Our Ref: WA/57/19/PL

**Town & Country Planning Act 1990 (as amended)
Town and Country Planning (Development Management Procedure) (England) Order 2015
Application for Planning Permission**

Development Rear Extension
Location Black Horse Inn Binsted Lane Arundel

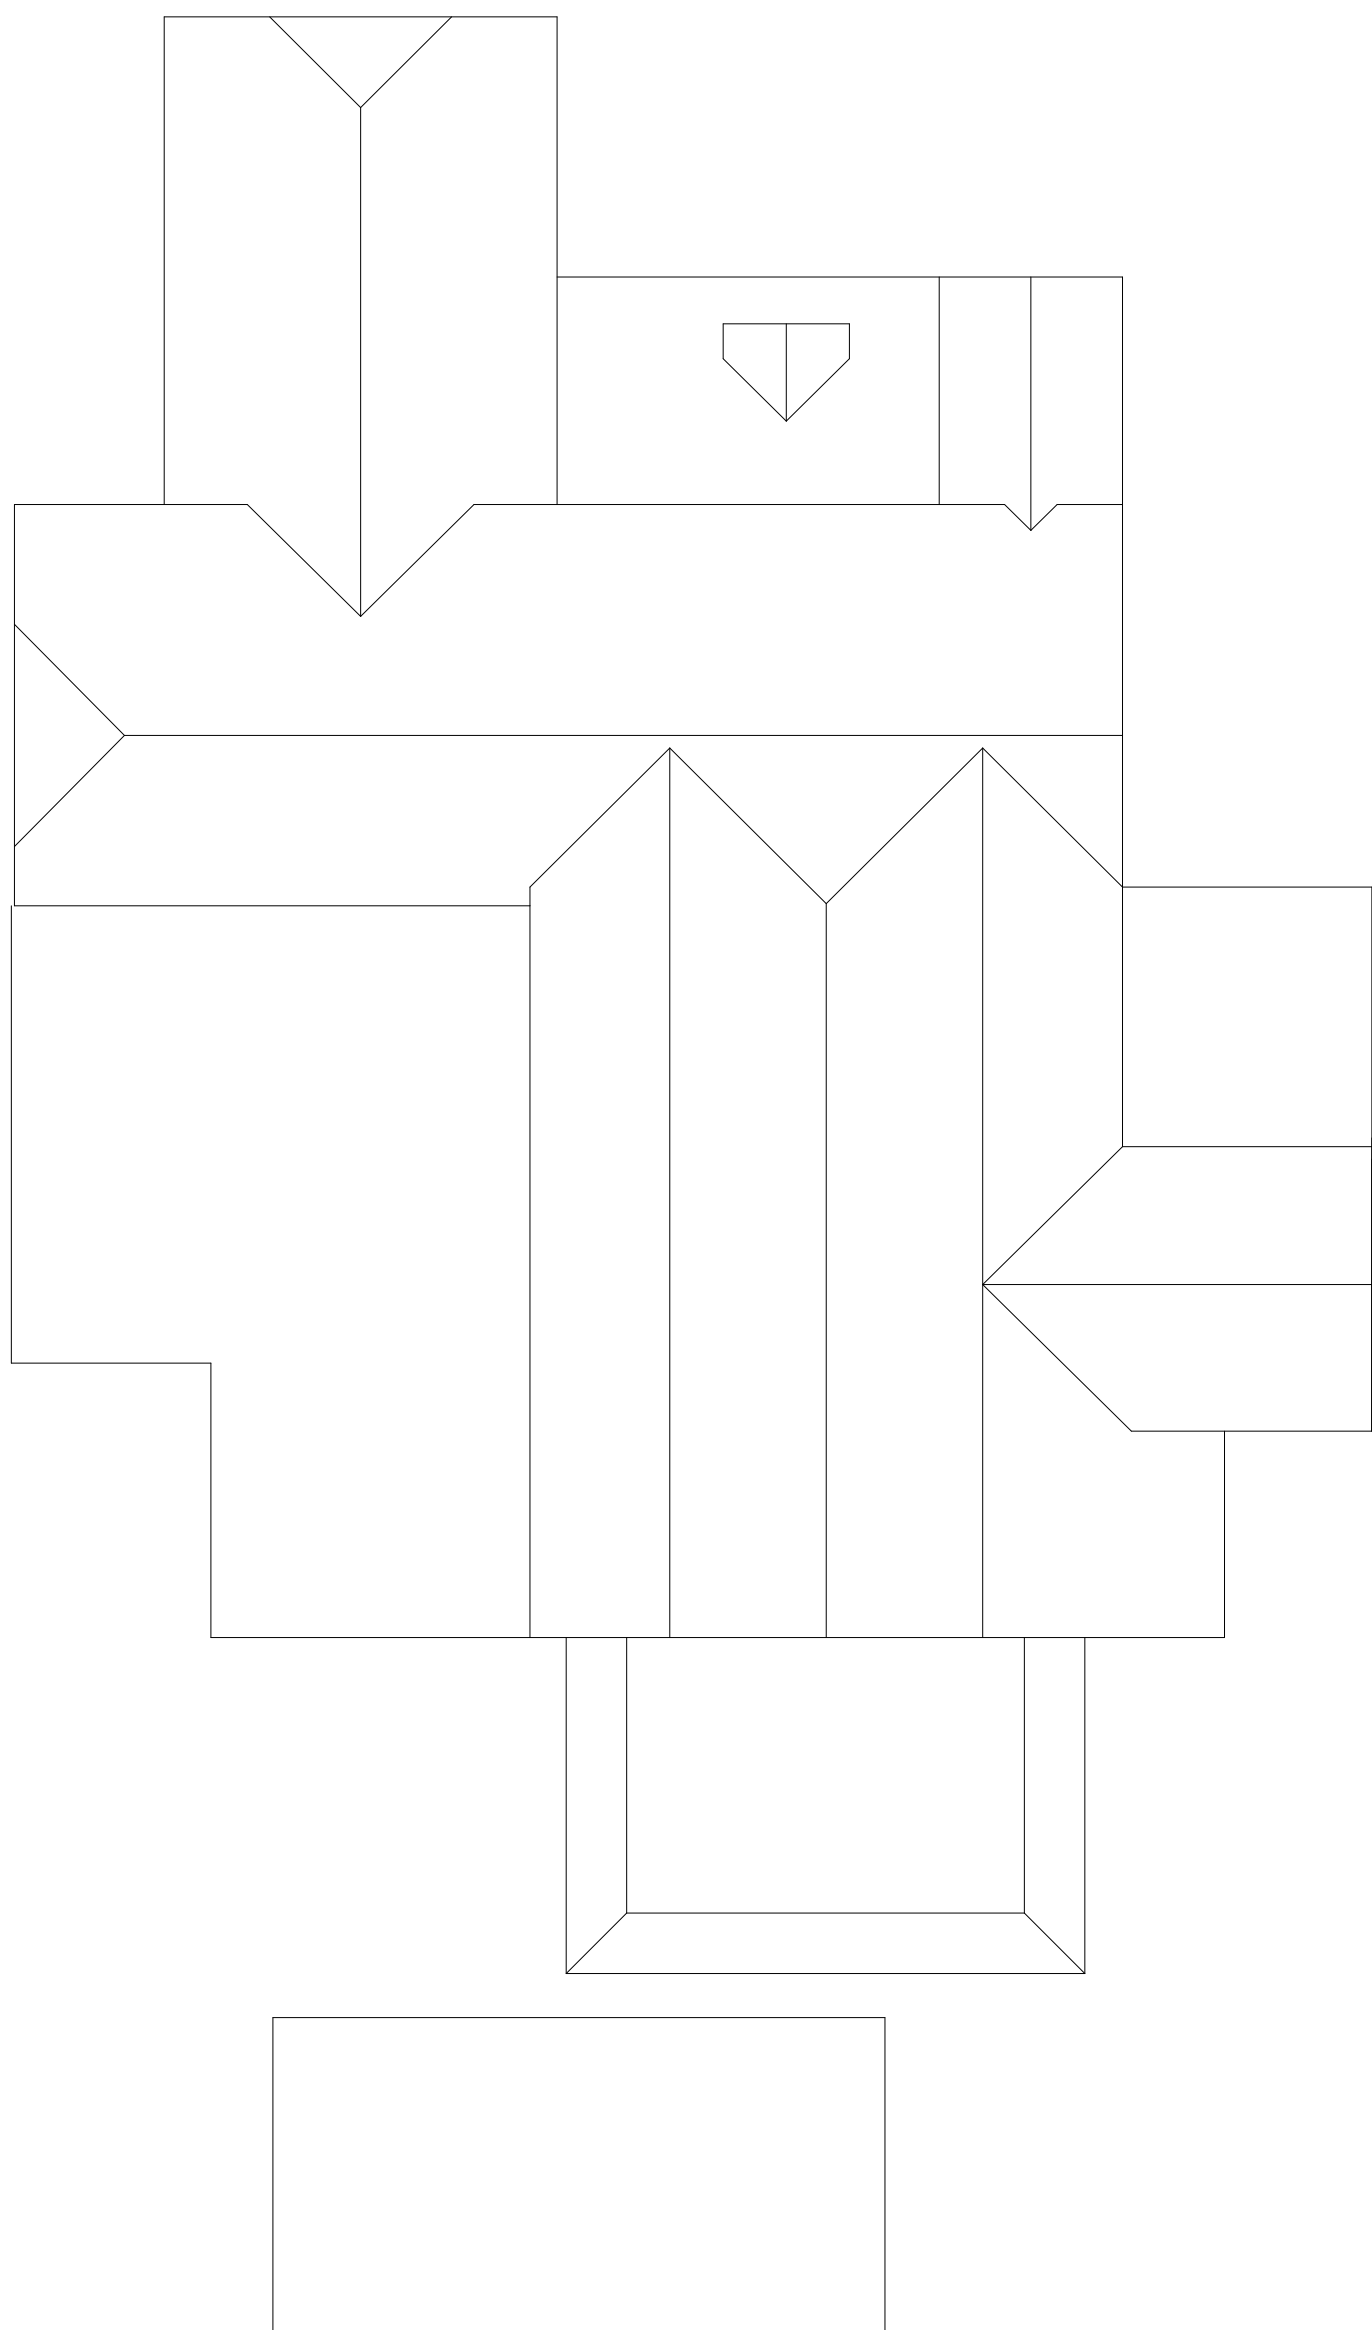
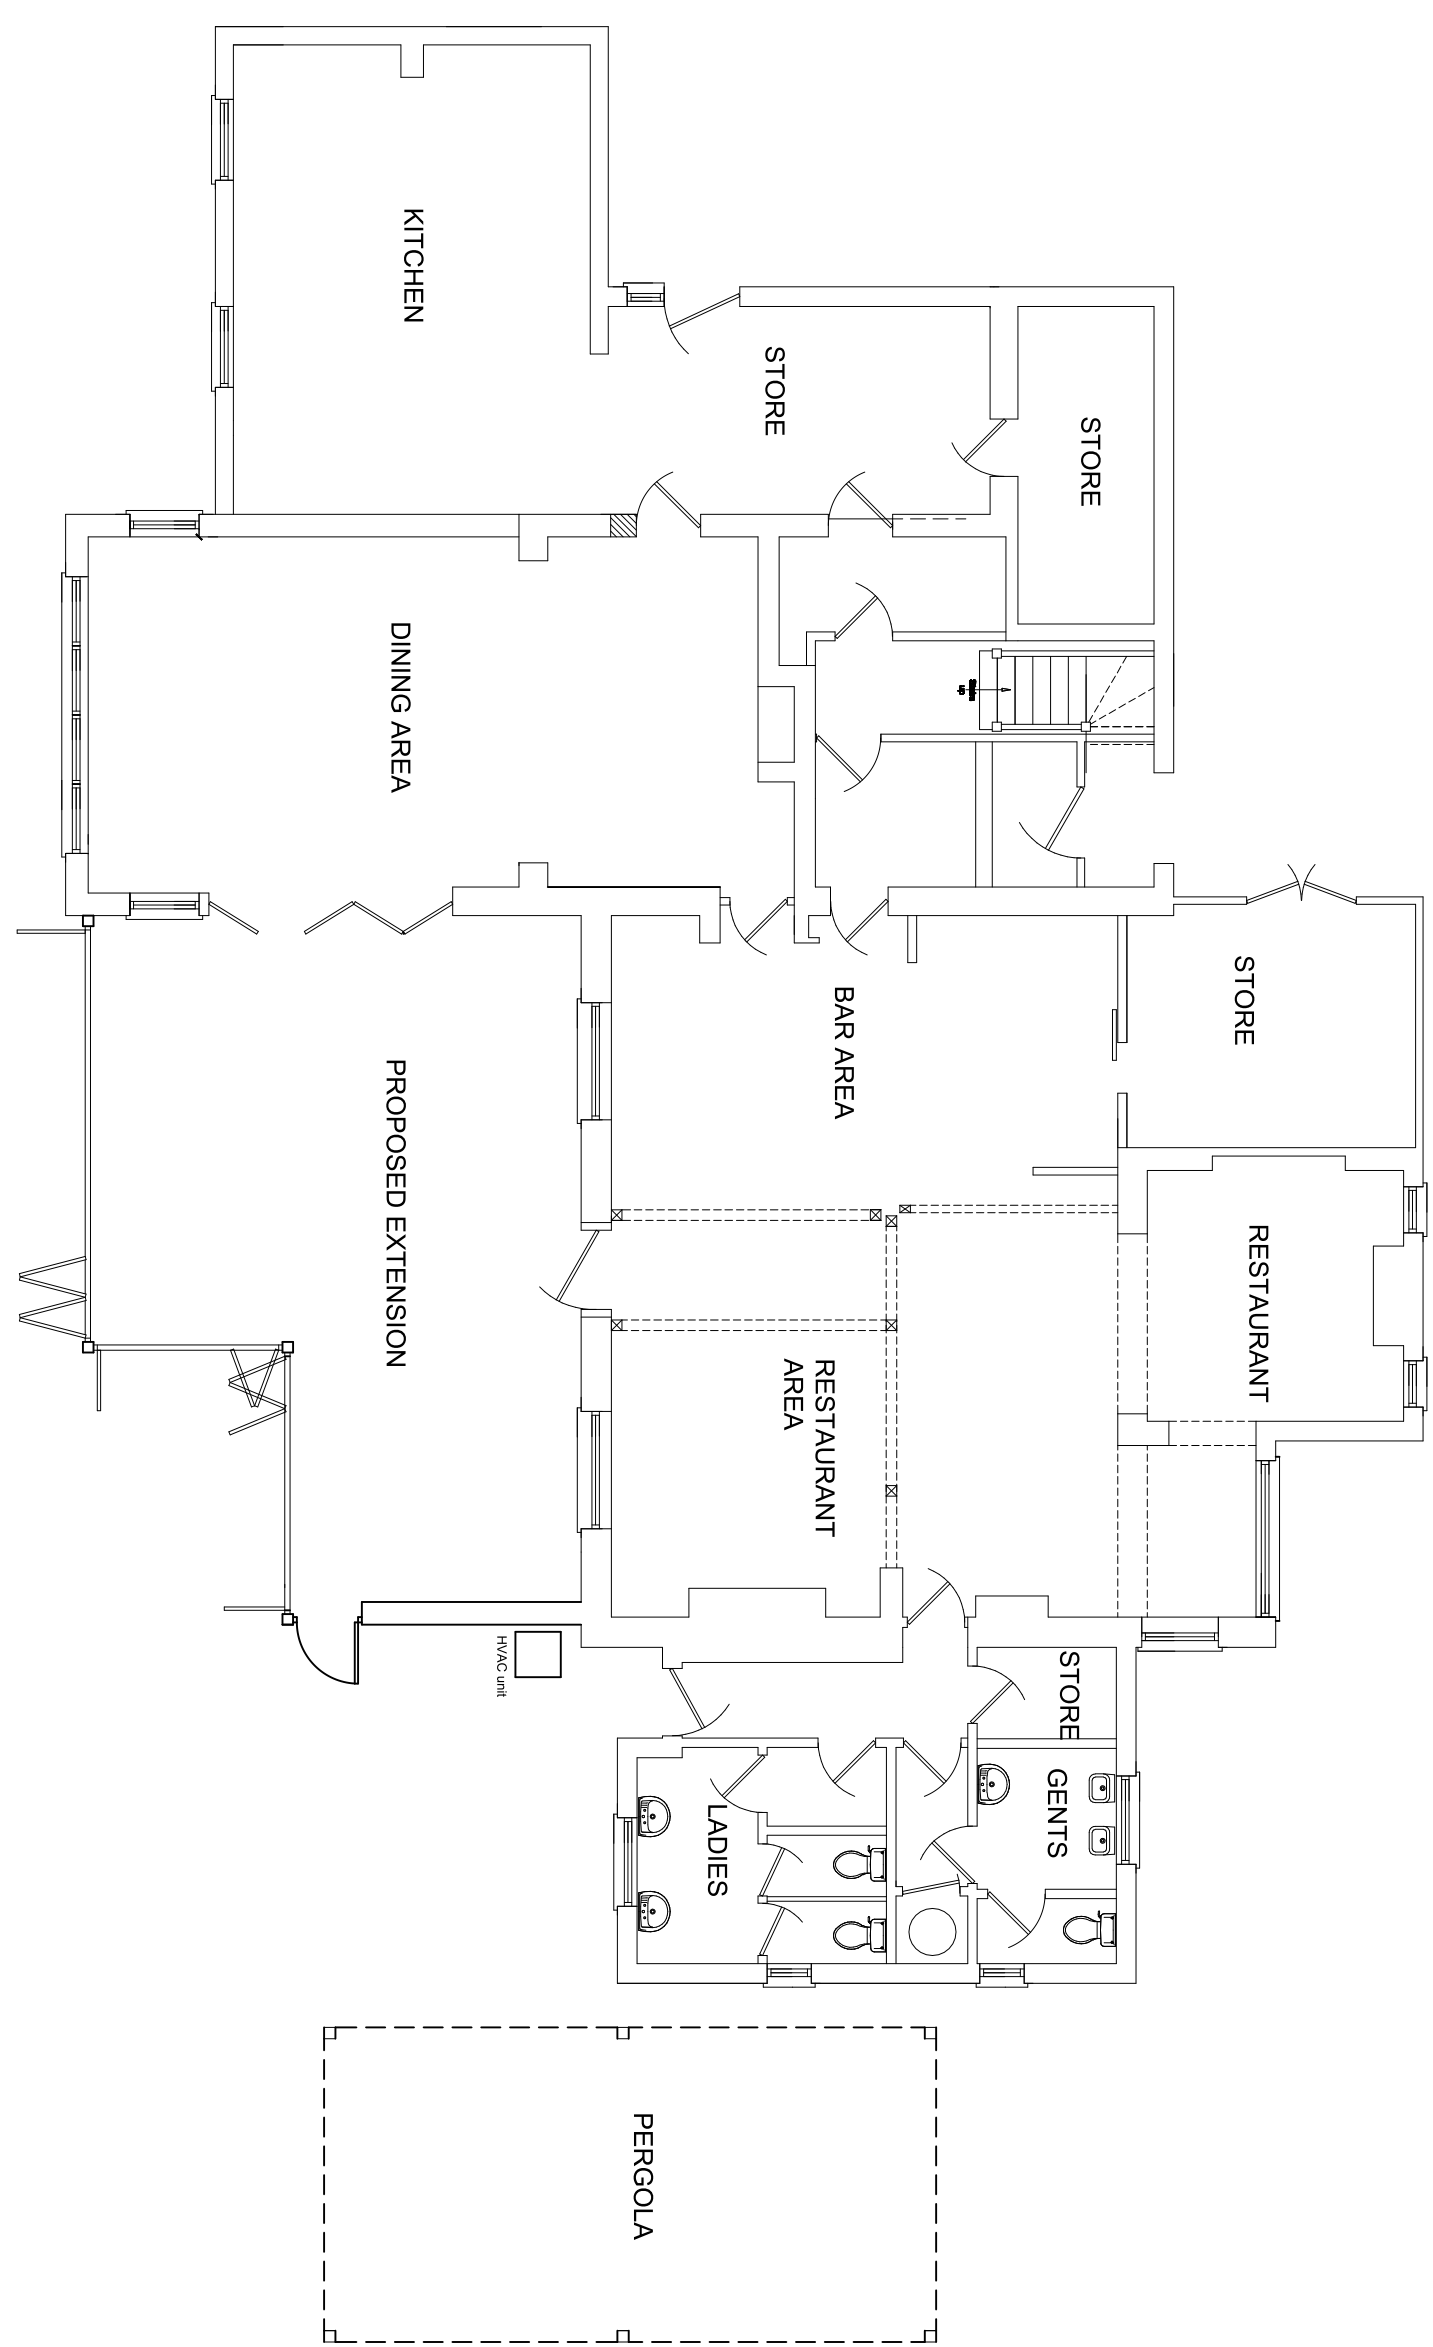
Confirmation Required: Please confirm whether you are applying for the HVAC unit under this application if so it will need to be included in the description with your permission we can include it in your description. If it is not it will need to be removed from your plans.
